Schools Infrastructure New South Wales

Lindfield Learning Village

Response to final submissions - Traffic and Transport

Issue | 28 August 2020

Landscape Blow Up Plan 8
Bus turnaround extended driveway zone

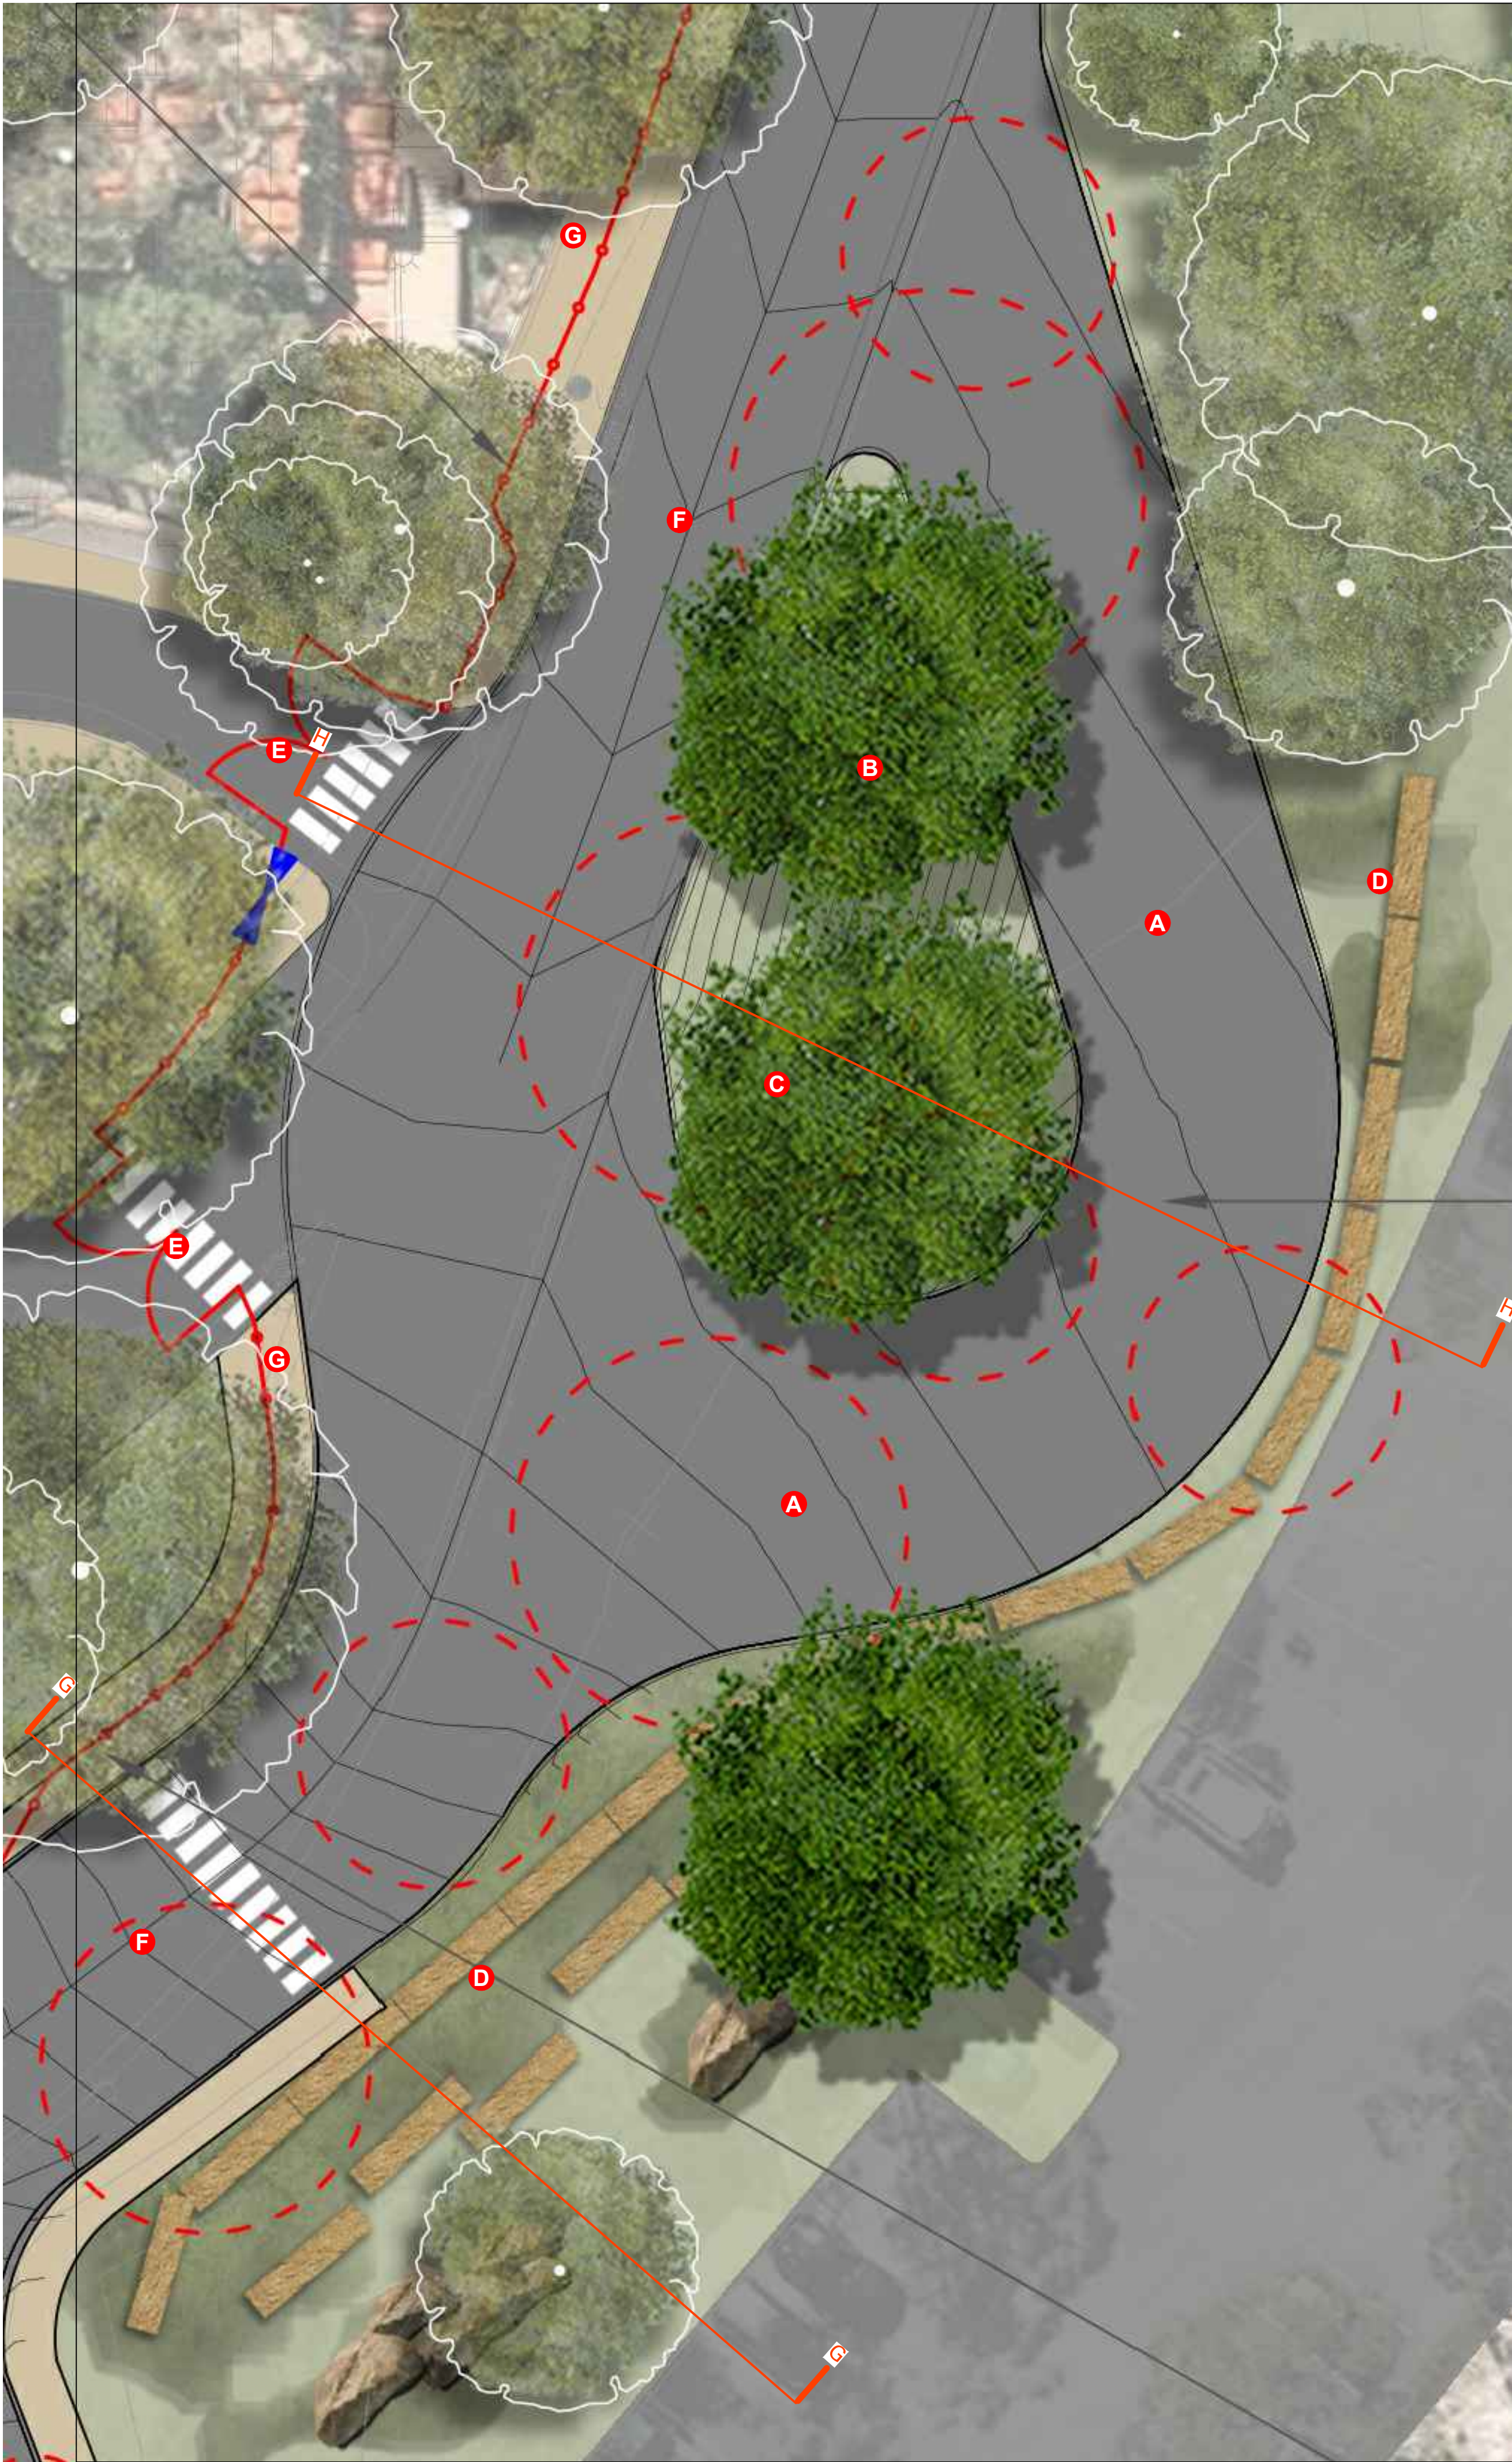
ID	Key Issue	Response
G4	<p>Dwg LA-2-0008: The circulation paths for cars and buses seem to clash in the bus turning area. Is there sufficient space for safe bus manoeuvring and car movement through this space?</p> <p>Must the student drop off by vehicles be so large? The Green Transport Plan should aim at reducing the number of private vehicles dropping children off at school. Consider reducing the extent of hard road pavement so that the turning circle of the car turnaround is aligned with the school entry plaza so that the area of pavement can be rationalised/ reduced."</p>	<p>The circulation paths do not overlap as shown in Appendix A. there is space for safe manoeuvres.</p> <p>The School Travel Plan aims to reduce car mode share to achieve a target of about 25% arrival by car. This still represents a significant amount of cars for this school which has influenced the size of the facility which has been designed to queue without impacting bus turnaround movements.</p>
